City of Portland, Maine - Building or Use Permit Application

Job No: 2012-11-5371-ALTR <i>2012 50084</i>	Date Applied: 11/8/2012	CBL: 182- C-004-001	
Location of Construction: 132 WAYSIDE RD	Owner Name: DIRECT REAL ESTATE HOLDINGS, LLC	Owner Address: 66 PEARL ST PORTLAND, ME 04101	Phone: 207-252-7574
Business Name:	Contractor Name: Rob Wing	Contractor Address: 66 PEARL ST PORTLAND MAINE 04101	Phone: 207-252-7574
Lessee/Buyer's Name:	Phone:	Permit Type: Building	Zone: R-3
Past Use: Single family	Proposed Use: Same - Single family - build an <i>20'x22'</i> attached garage. <i>22'x22'</i>	Cost of Work: \$21,000.00	CEO District:
		Fire Dept: <input checked="" type="checkbox"/> Approved <i>w/conditions per Ct. Wallace</i> <input type="checkbox"/> Denied <input type="checkbox"/> N/A	Inspection: Use Group: <i>R3</i> Type: <i>SB</i> <i>IRC, 2009</i> <i>MUBER</i> Signature: <i>[Signature]</i>
Proposed Project Description: New Attached Garage <i>20'x22'</i> <i>22'x22'</i>		Permit Activities District (P.A.D.)

has permission for an addition of 22' by 22' attached garage (Single Family Residence).

Conditions of Approval:

New Door TO BE installed For Entry

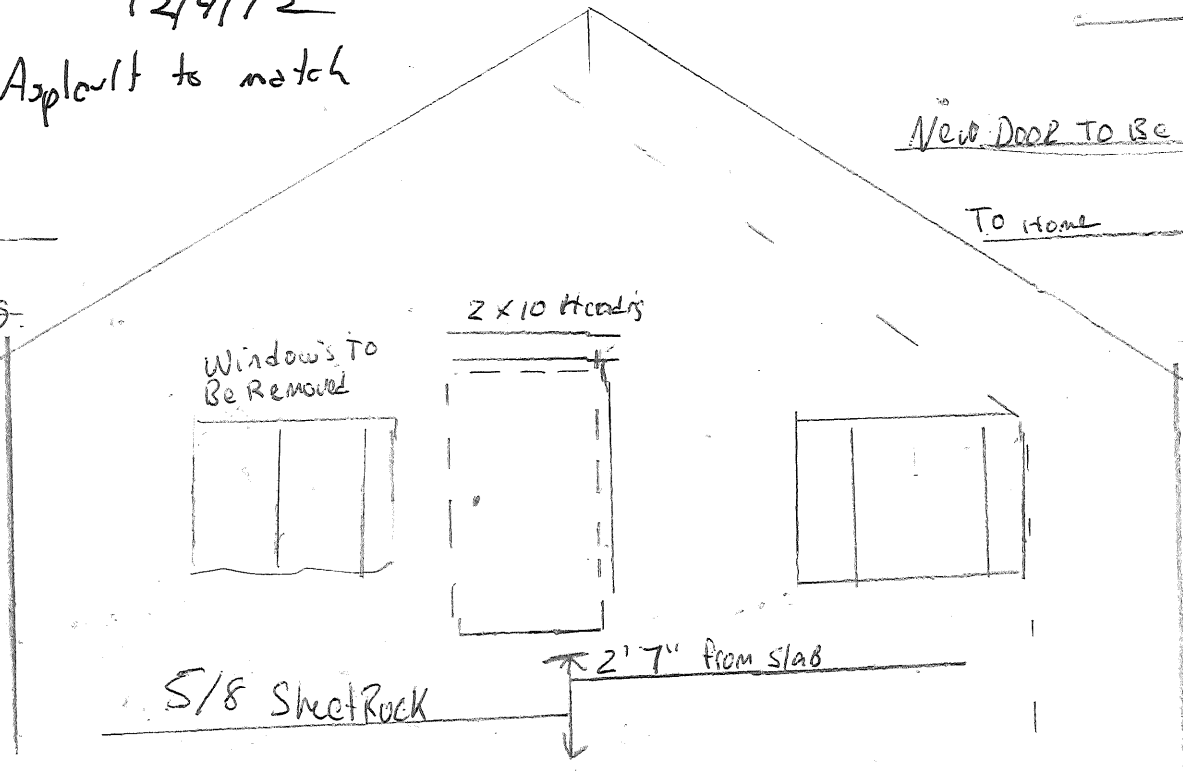
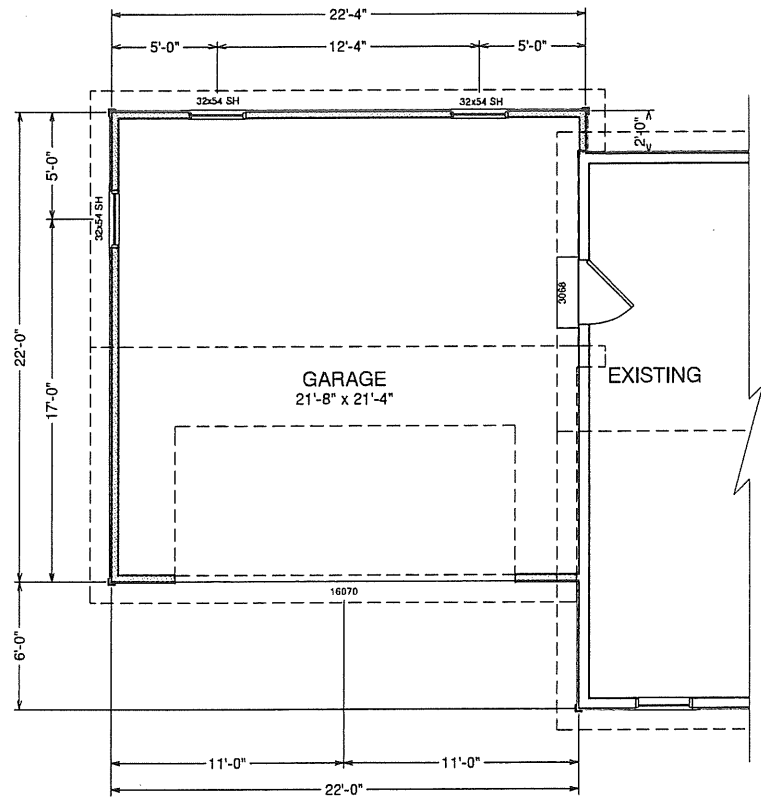
6. The door opening between the garage and residence shall be equipped with solid wood doors not less than 1 3/8" inches in thickness, solid or honeycomb core steel doors not less than 1 3/8 inches thick, or 20-minute fire-rated doors.
7. Note: Submit specifications for engineered trusses & beams to this office prior to construction.

9' Frost walls
6" Slab
10" Footing To Be
Tied in To Existing Foundation

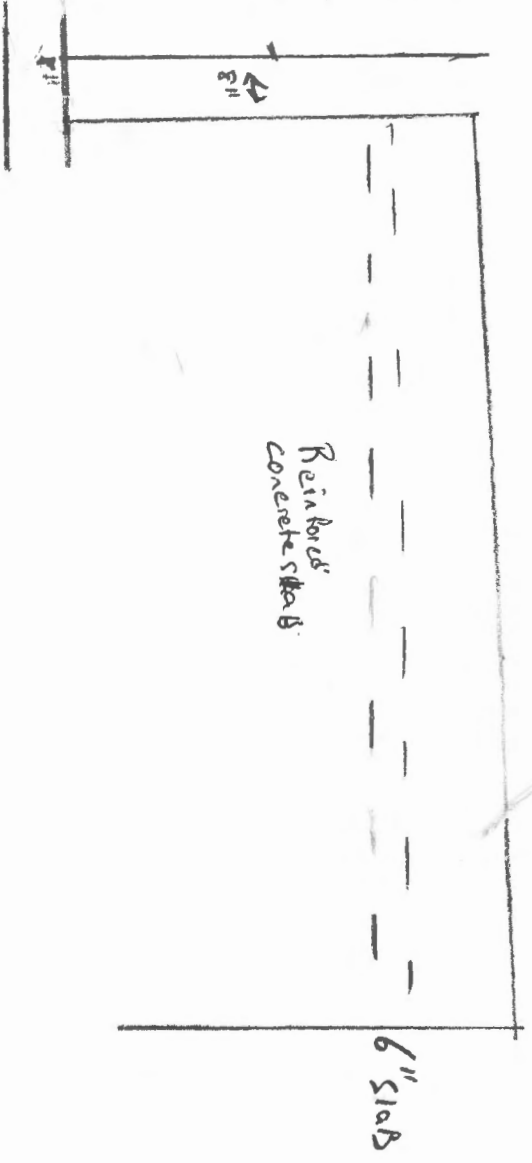
2. Frost protection must be installed per the enclosed detail as discussed w/owner/contractor (at least 4' from grade).
3. Section R317 Protection of Wood and Wood Based Products against decay. All wood framing members that rest on concrete or masonry exterior foundation walls and are less than 8 inches from the exposed ground.
